From: Simon Davis
Sent: 17 December 2021 16:07
To: 'Nathan Chilvers' [REDACTED]
Cc: Adrian Bristow [REDACTED]
Subject: RE: 0412 - RE: BN/160/21/NMA Tars Farm

DRAWING TITLE:
Site Plan - Non-Material Amendment Submission

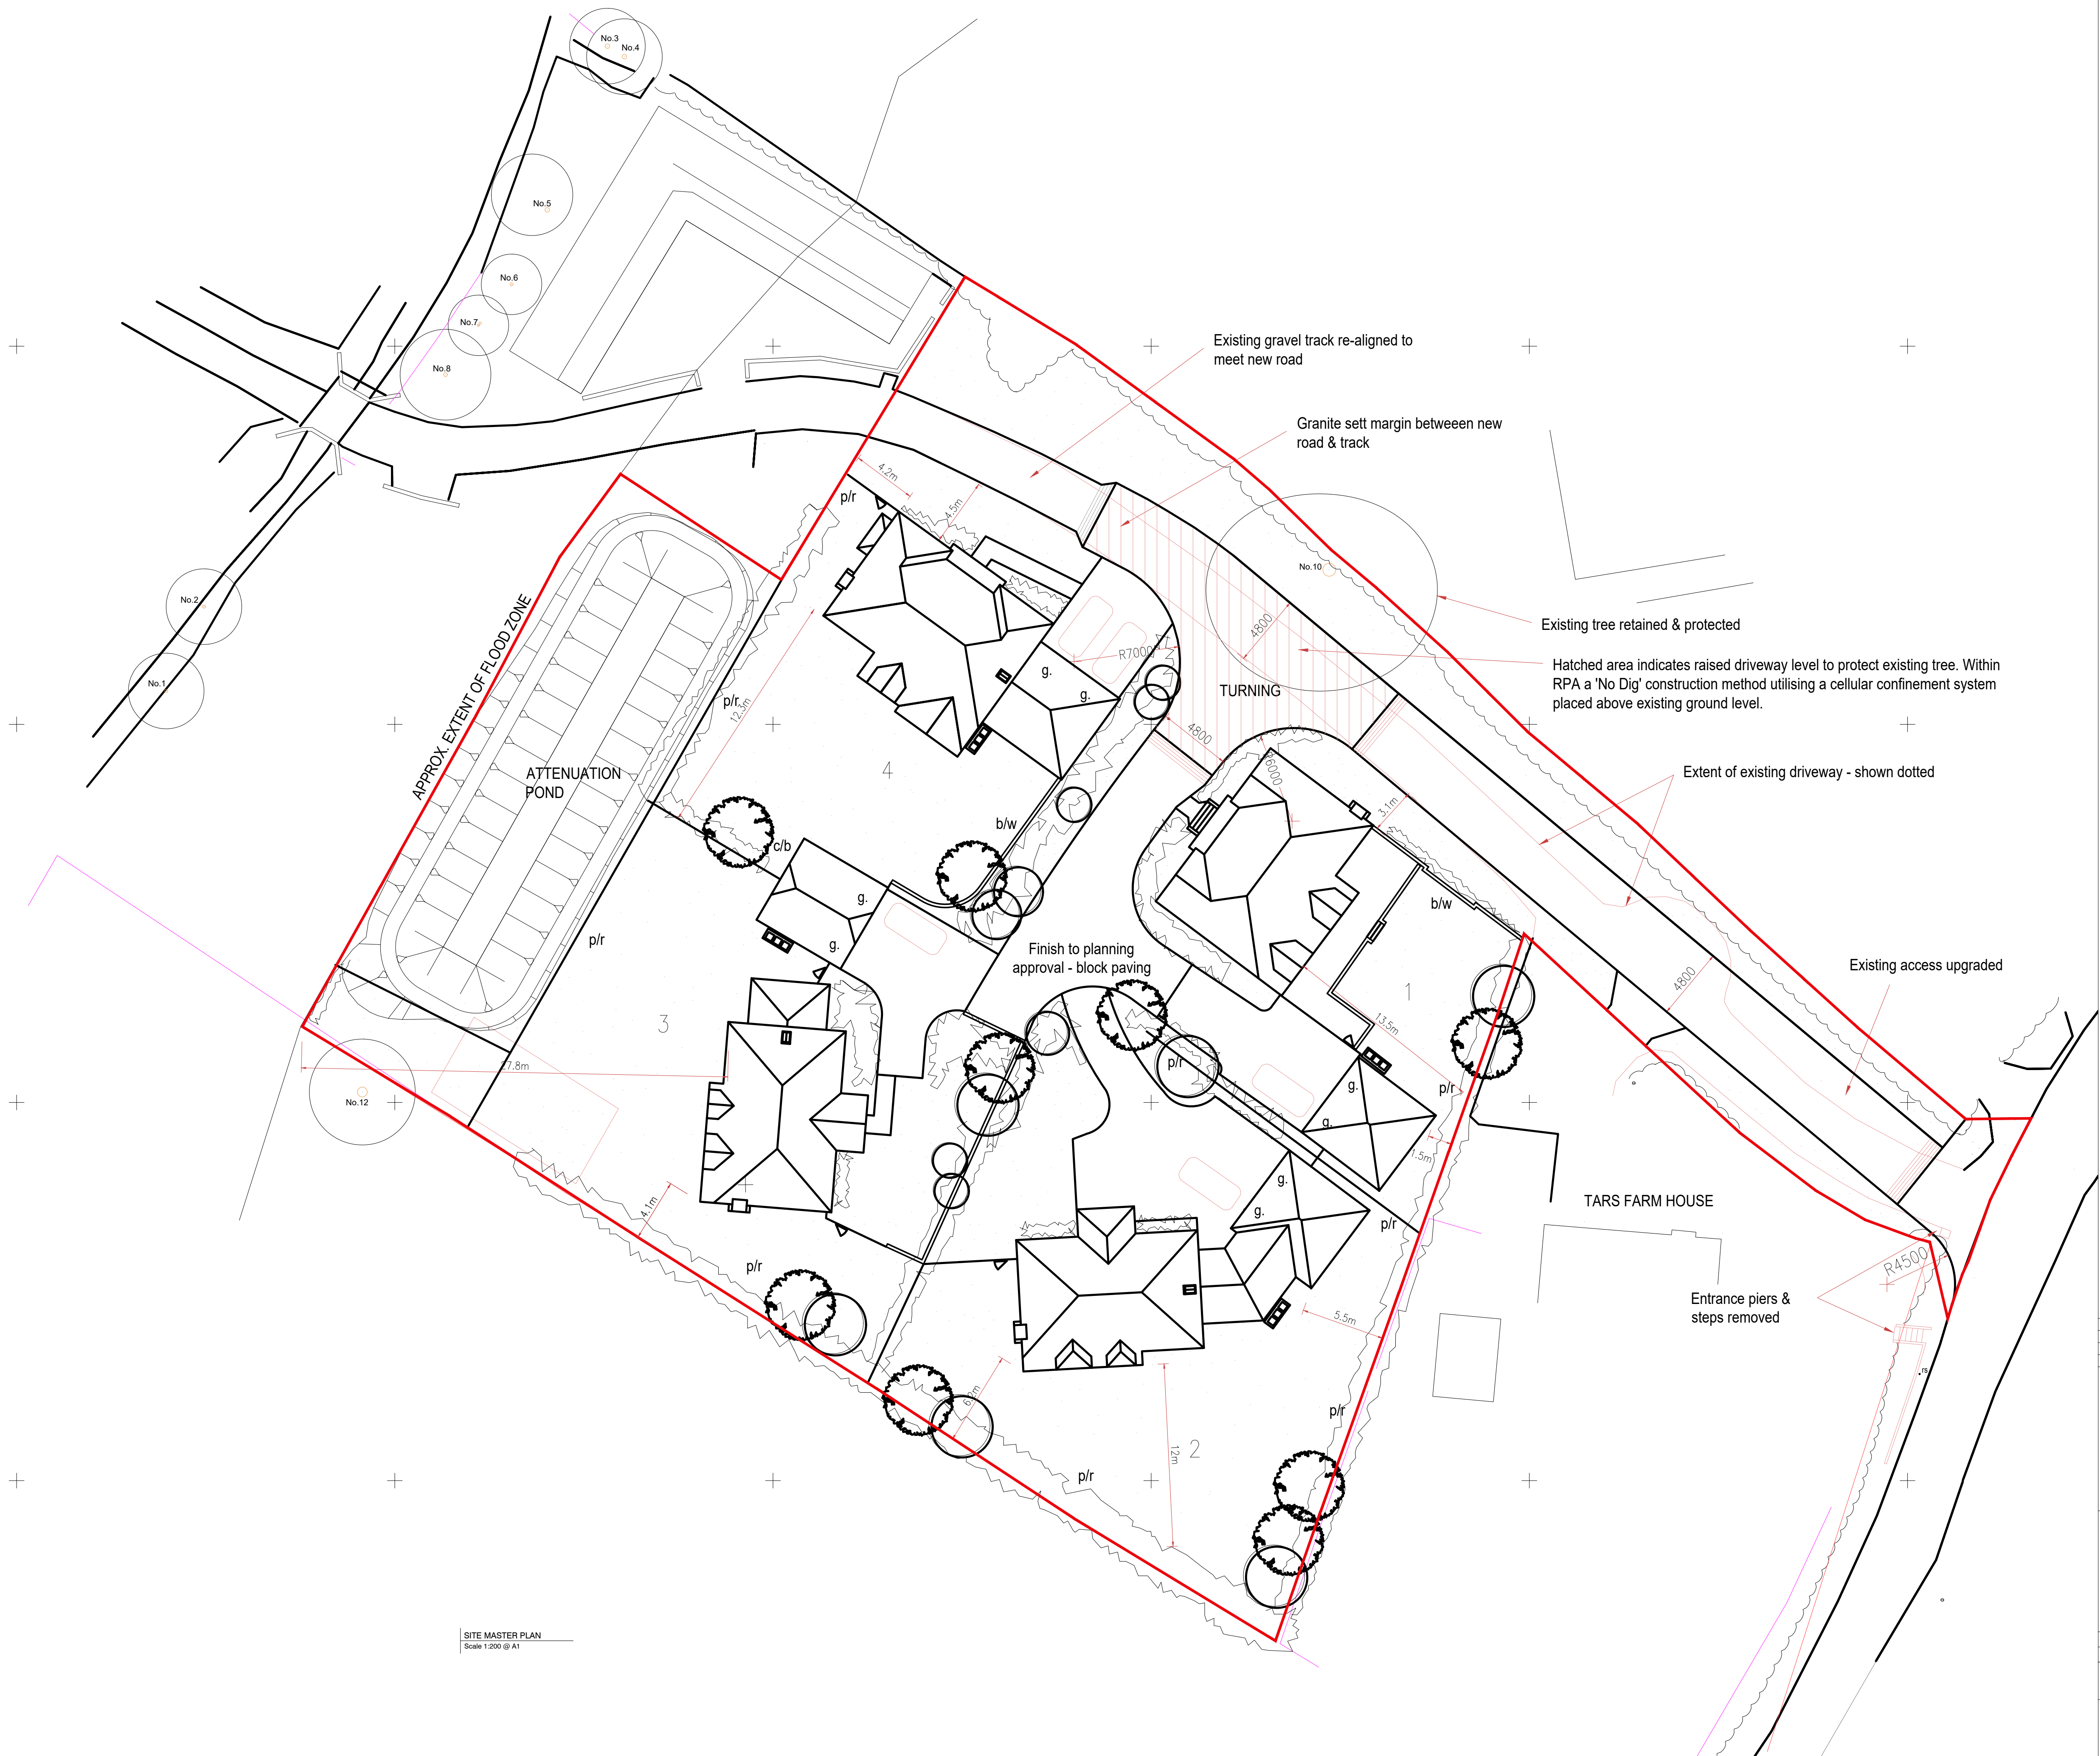
I note that you have partly applied to change the driveway surfacing material from block paving to gravel to match the existing access track. Can you confirm whether this is loose gravel or resin bound as it isn't clear from the drawings? Note that we would not want to see loose gravel as it may clog up the drainage gullies.

The client is happier with block paving (over resin bound) as originally consented I believe.
